**Dinuka McKenzie - M5 Planning Submission**

## Submission on Expansion of M5 To Planning NSW

Please accept the following submission for more design and planning of sound mitigation on the expansion of the M5 through the Georges River West Bridge residential receivers areas which have been overlooked by the Noise Mitigation Report.

Figure 8.7 Location of existing and proposed new or augmented noise walls

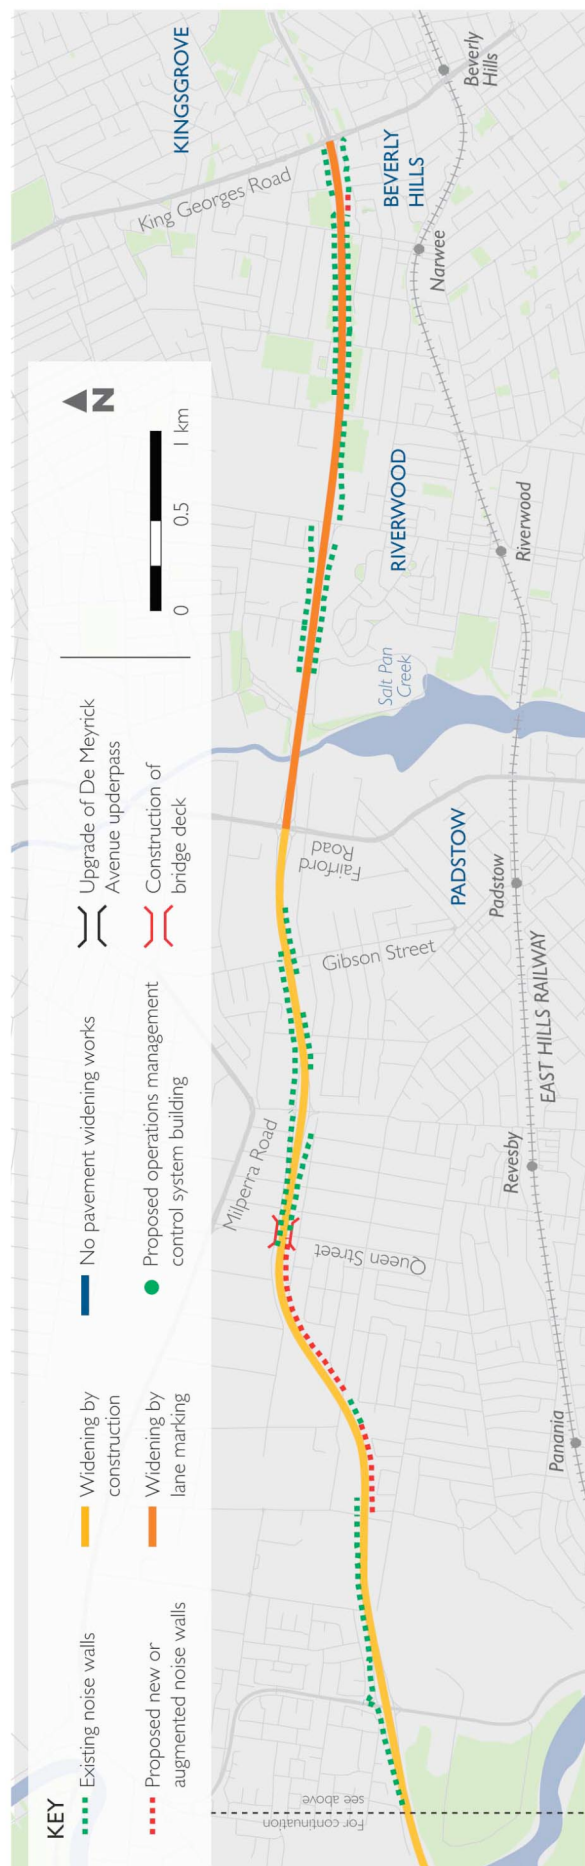
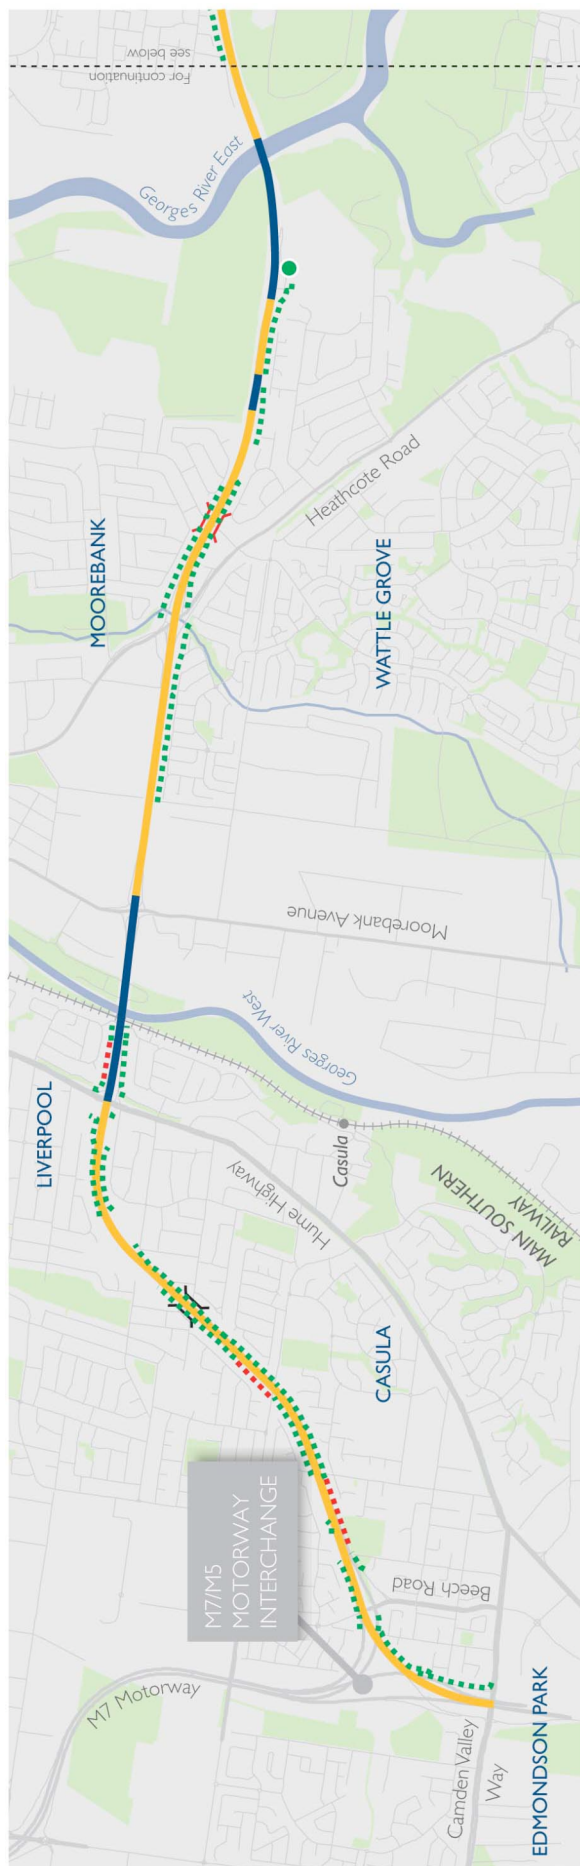
George River west bridge has noise mitigation on both the east and west areas of the M5 around the Bridge. There are noise mitigation barriers between the Moorebank Rd end and the Hume highway end of the bridge. This is the bridge area and as this section stipulates “For all residences requiring mitigation, the process adopted to mitigate the noise is as follows:” See Dot Point One “ New Noise barriers ( where existing gaps in the barriers exist) Therefore the M5 bridge which has a gap in the noise mitigation must receive new noise barriers because it is also reasonable and feasible.

This section shows bridge section above Georges River between Moorebank Ave. and Hume Highway at Casula where no sound barriers are recommended to be installed . Please note well the houses along either side of the bridge and further along the riverbank where no sound record has been conducted..

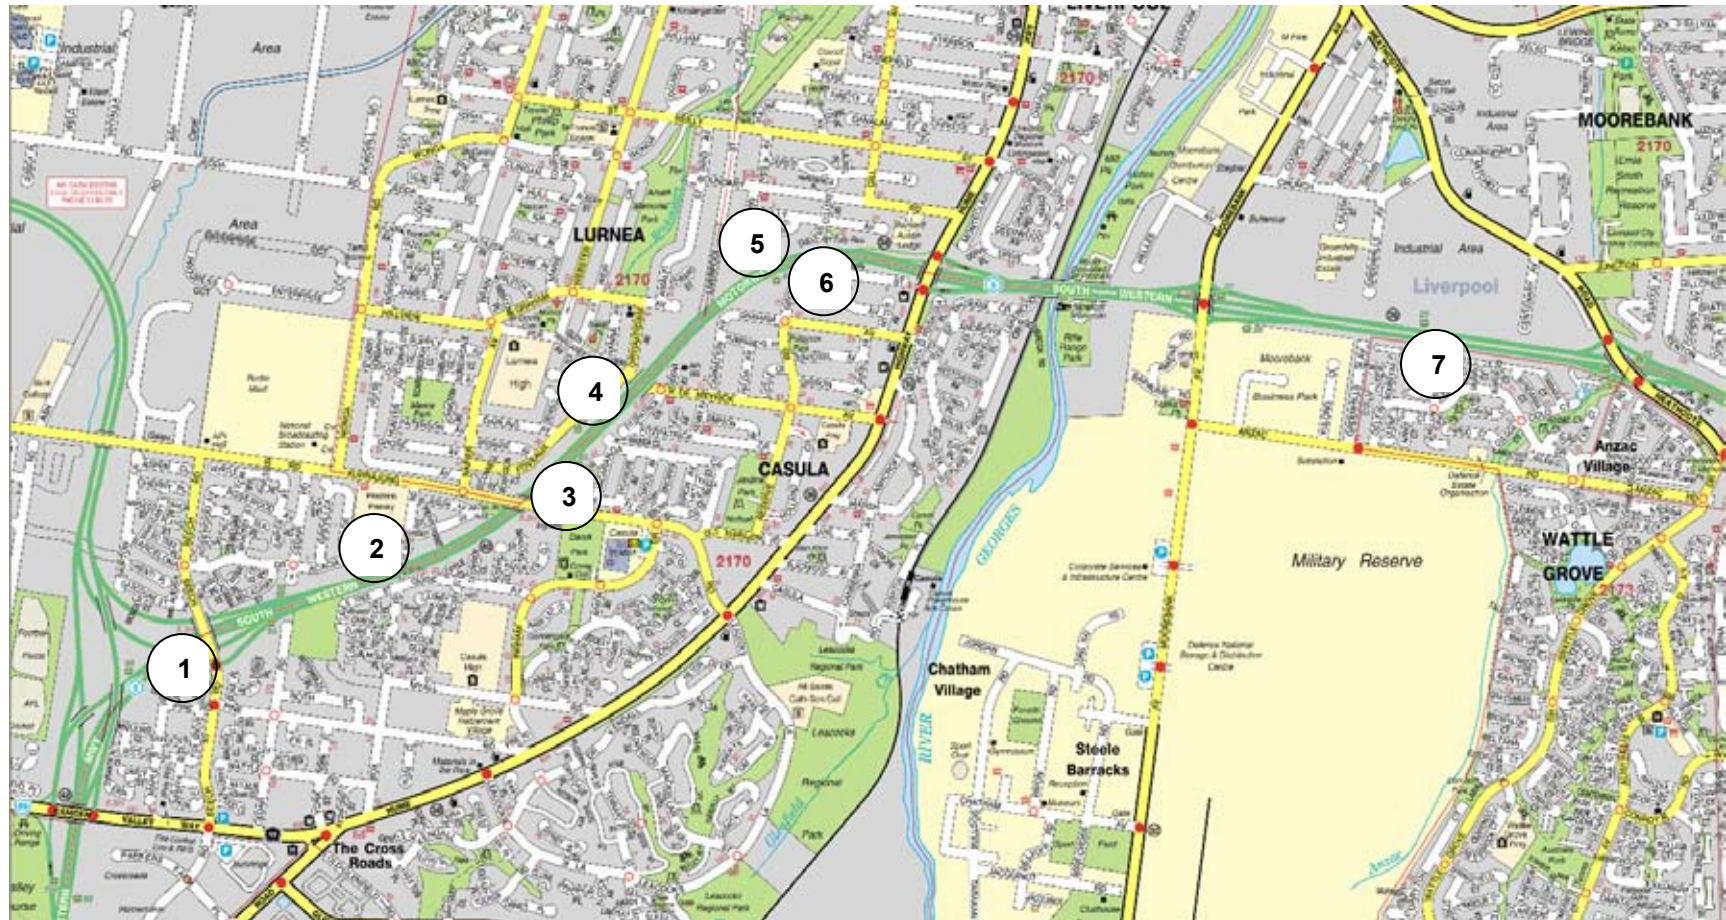
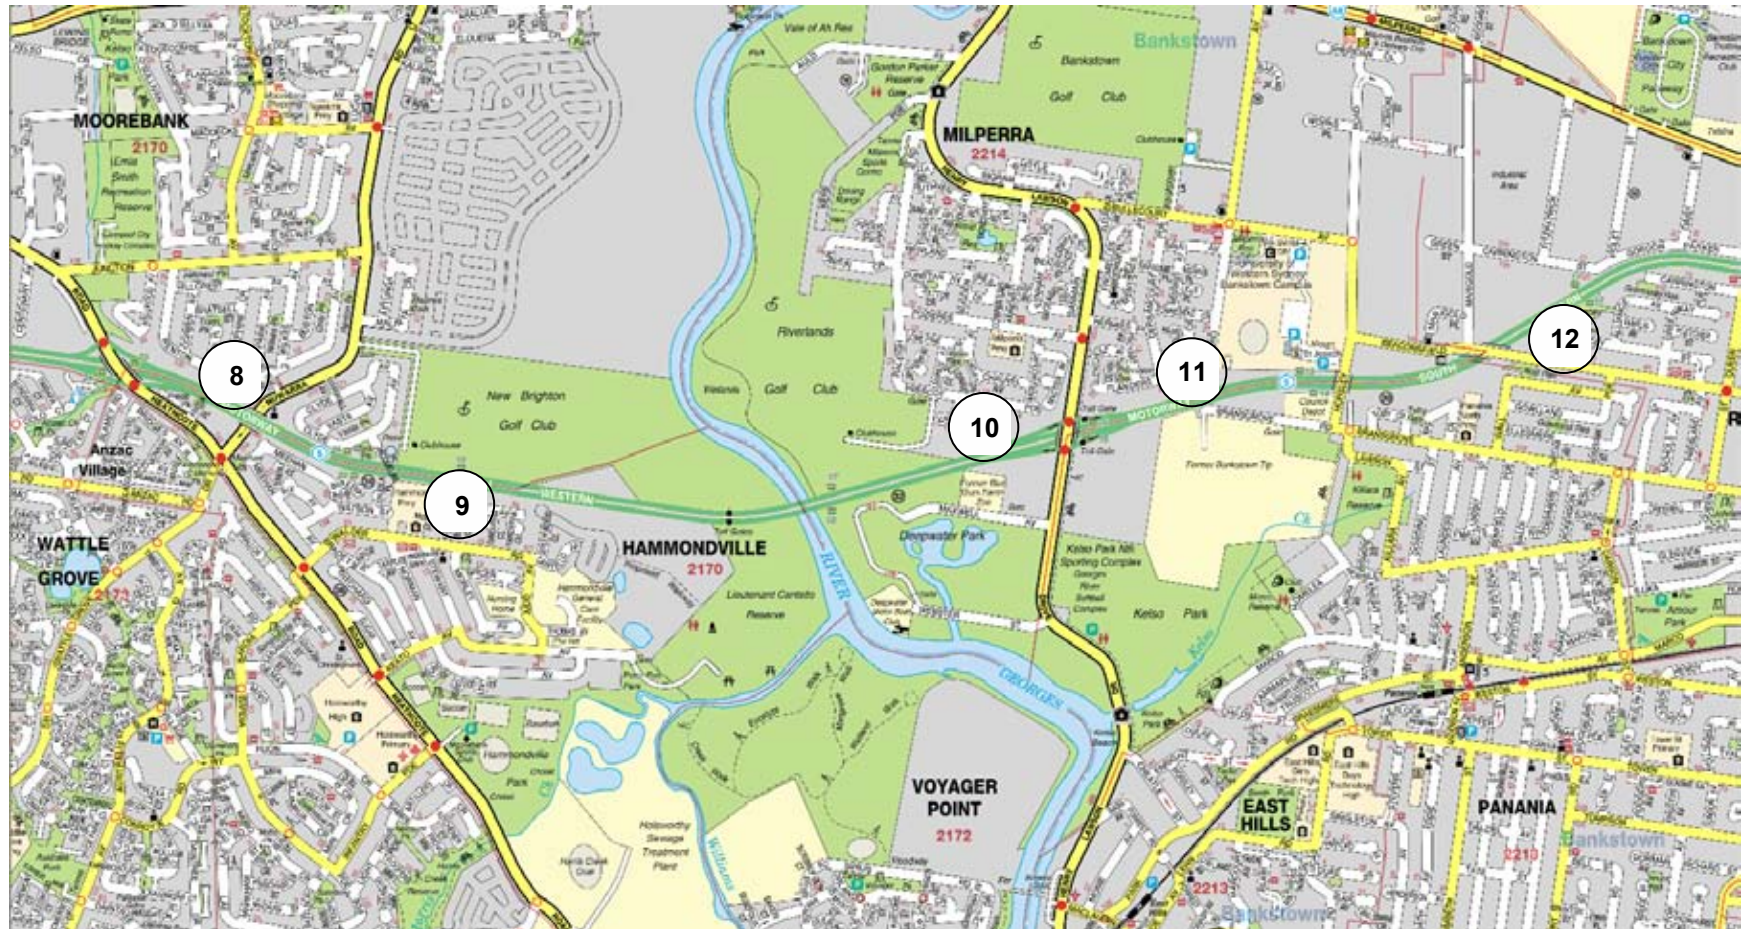
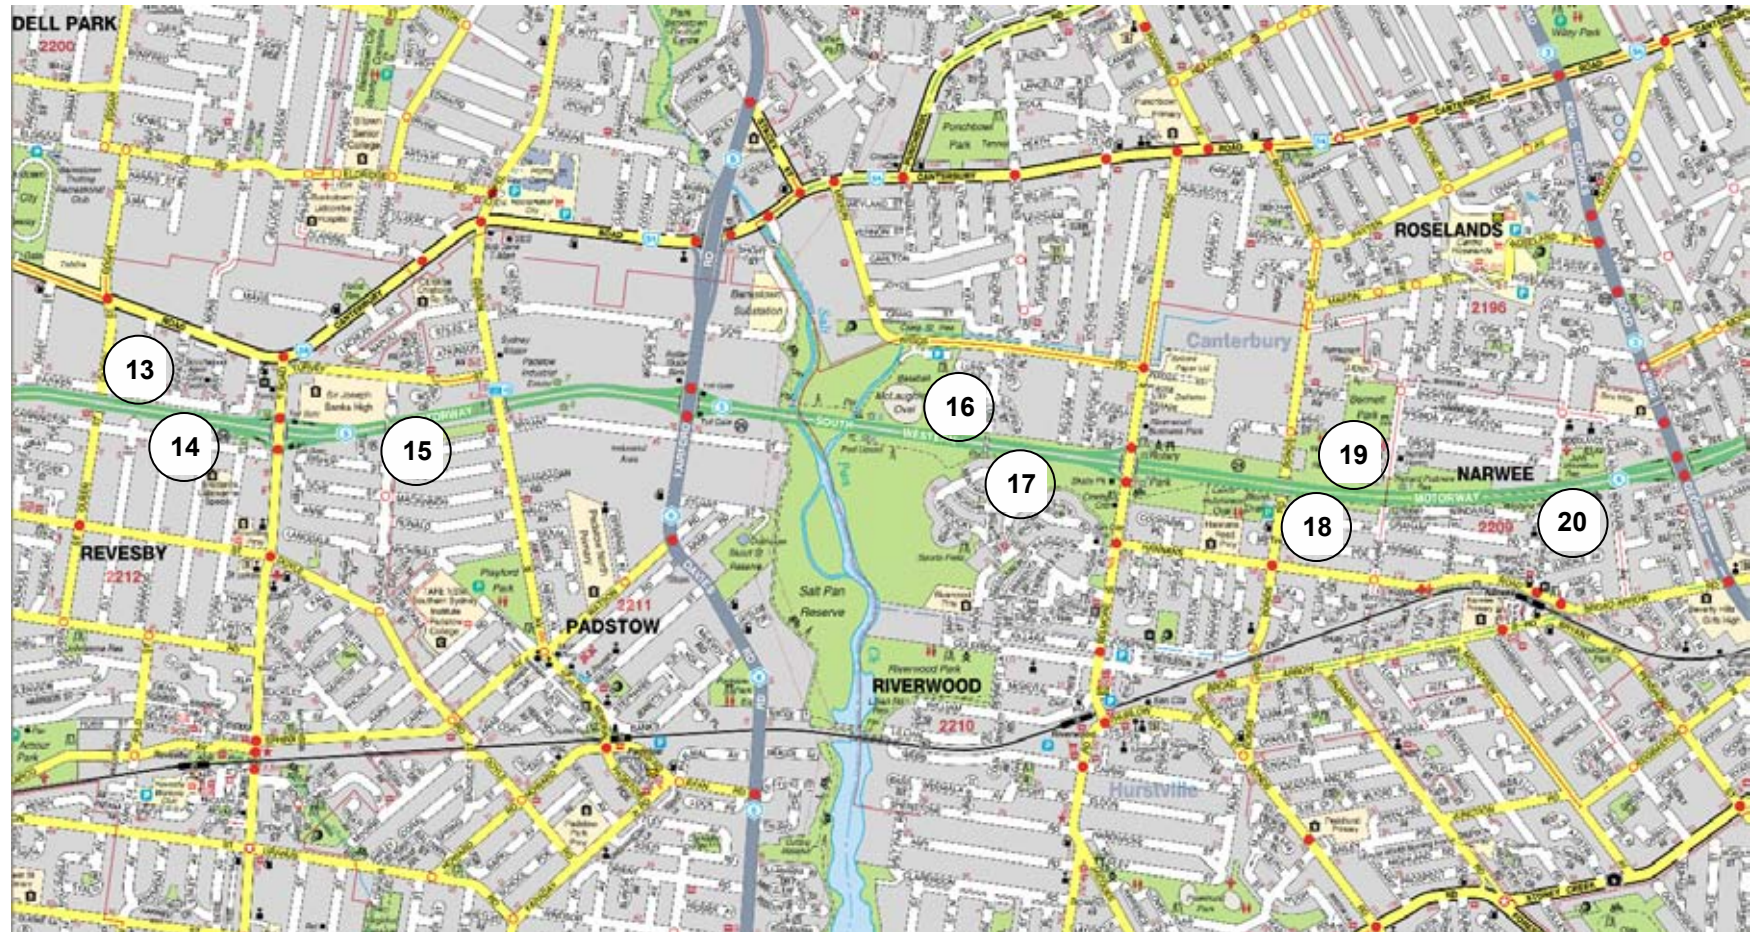
Appendix A Heggies Report 10-8495 Receivers testing location.  
 Note Receivers 6 and 7 have not addressed areas on lower residential receivers along Georges River foreshore houses and significant parklands.

Existing VMS locations (pink) and new VMS localities (green)

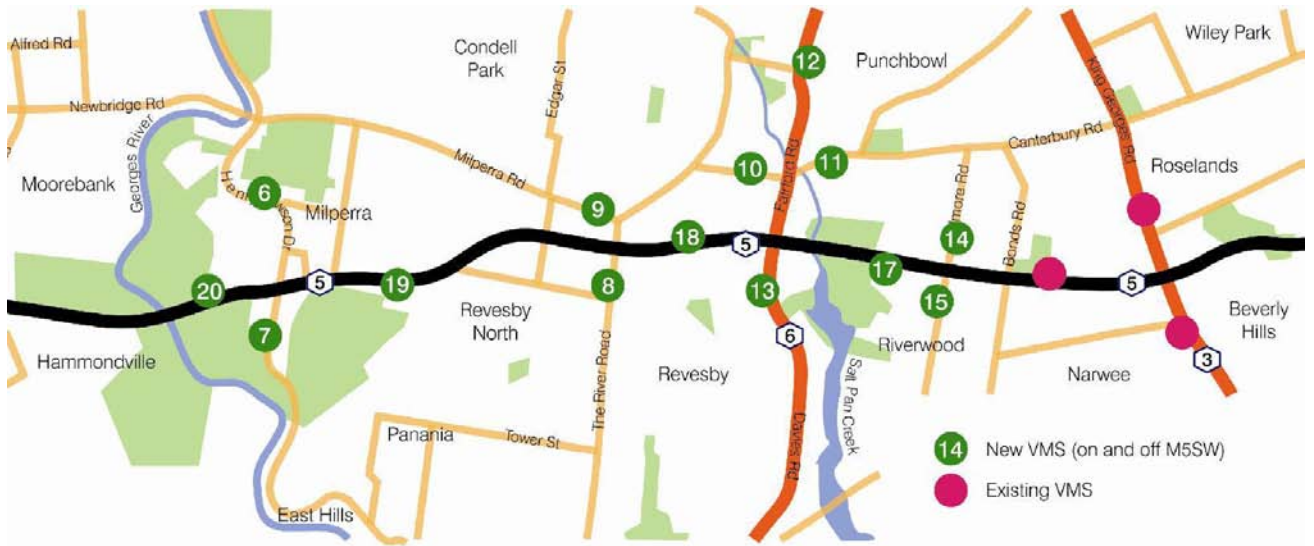
On the issue of VMS please take into consideration that many vehicles leave feeder roads to travel along the M5 around Tempe, Bardwell Park, Beverley Hills, Roselands etc and find it very frustrating to find it is closed for maintenance or blocked by congestion

VMS screens need to be position so that motorists are informed either before they leave feeder road ( say Canterbury Rd) or at a intersection where upon seeing VMS information can turn away from M5 back to feeder road and therefore use M5 warning message to bypass trouble.
